December 28, 2022

RE: Responses to TCL Comments
Dutch Bros Coffee (NM-0203)
NEC - 98th Street N.W. and Volcano Road N.W., Albuquerque, New Mexico 87121
Our Job No. 22187

1. Traffic Circulation Layout Plan

Job Number  
**22187**  
Sheet  
**C2.0**  
2019 DB  
Franchising USA, LLC

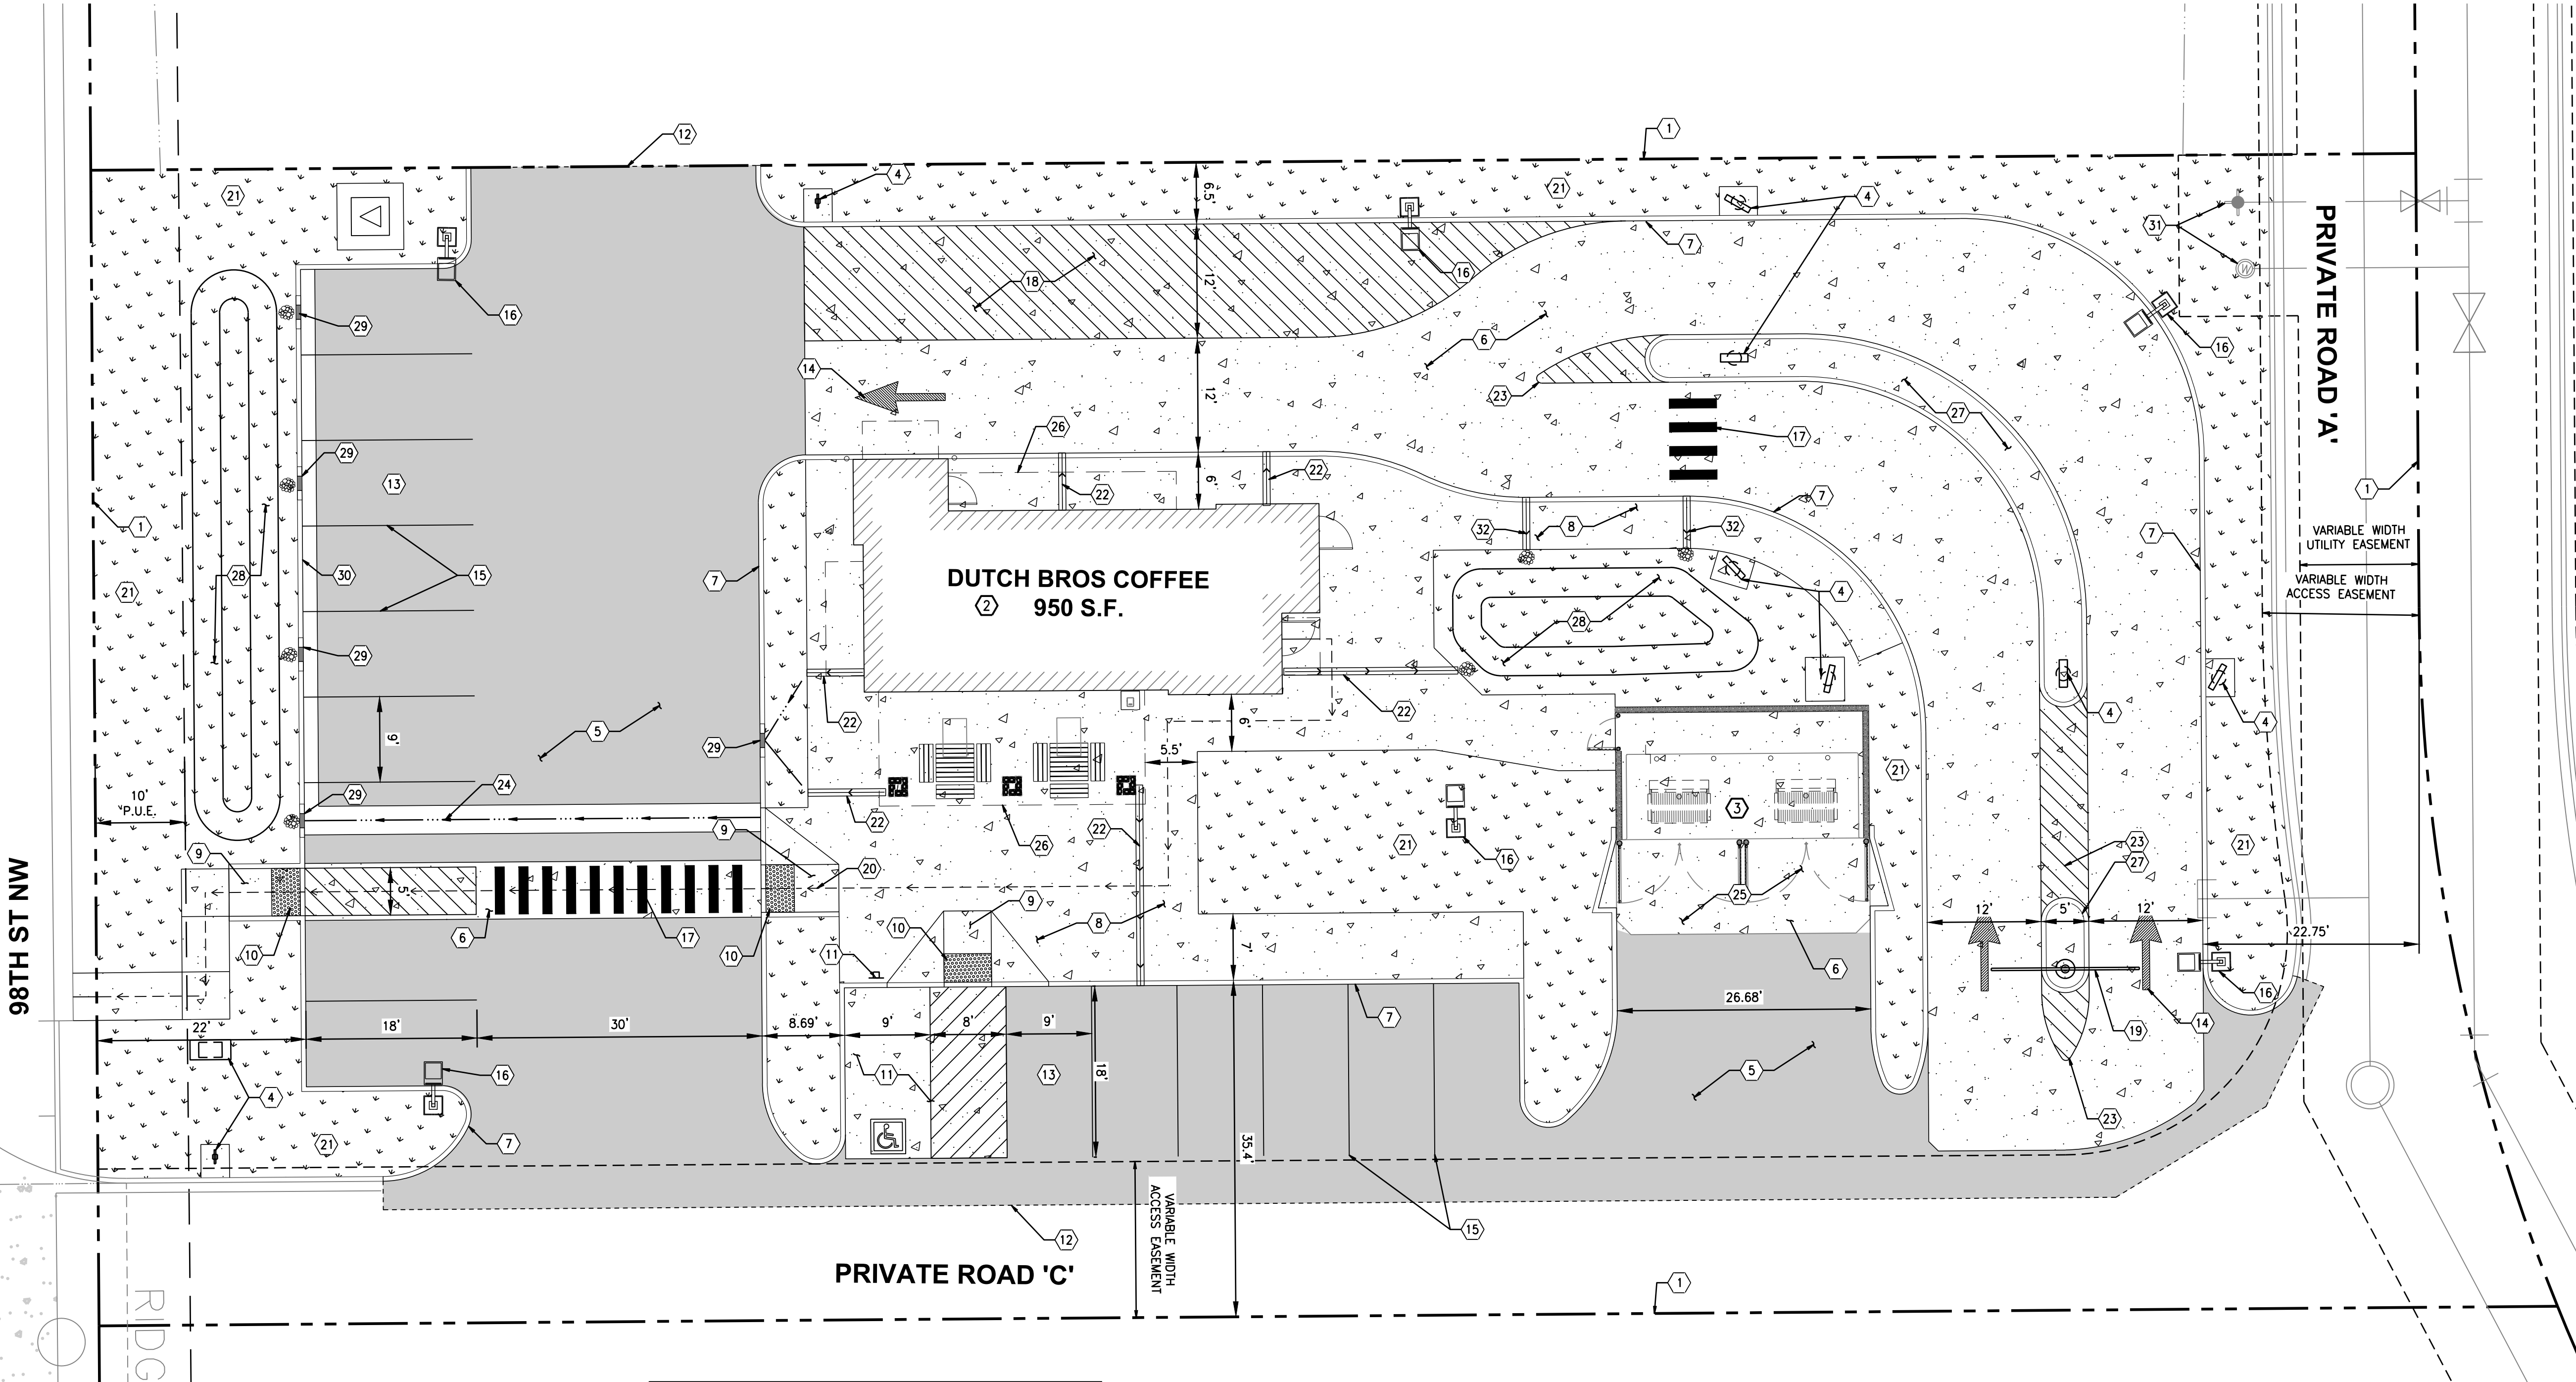
6. *Signs. Provide sign face detail drawings for all proposed traffic signs. One-way, Do Not Enter, Motorcycle Parking, Handicapped parking with fine.* **One-way and motorcycle signs missing**

7. *Place the one-way and do not enter signs with appropriate pavement markings in the site plan. Not done*

8. *Add one Motorcycle Parking space with sign Not done*

9. *Add three bicycle parking spaces. Provide bicycle rack details. Not done*

13. *Increase the pedestrian sidewalk/pathway from the public sidewalk to the main entrance to 6 feet. Plans have a 5-foot wide path. Dimension missing, not clear where the sidewalk is.*

14. *Show the sight triangles for the driveway on 98th and the driveway into the site. Not done*

Response: One-way and motorcycle signs have been noted on C2.0 accordingly.

Response: Appropriate pavement markings have been included in the site plan.

Response: Two motorcycle parking spaces have been included in the site plan.

Response: Three bicycle parking spaces have been included in the site plan. Additionally, a bicycle parking rack detail has been included.

Response: The pedestrian path has been revised to meet the minimum 6-foot sidewalk width requirement.

Response: Sight triangles have been included accordingly.
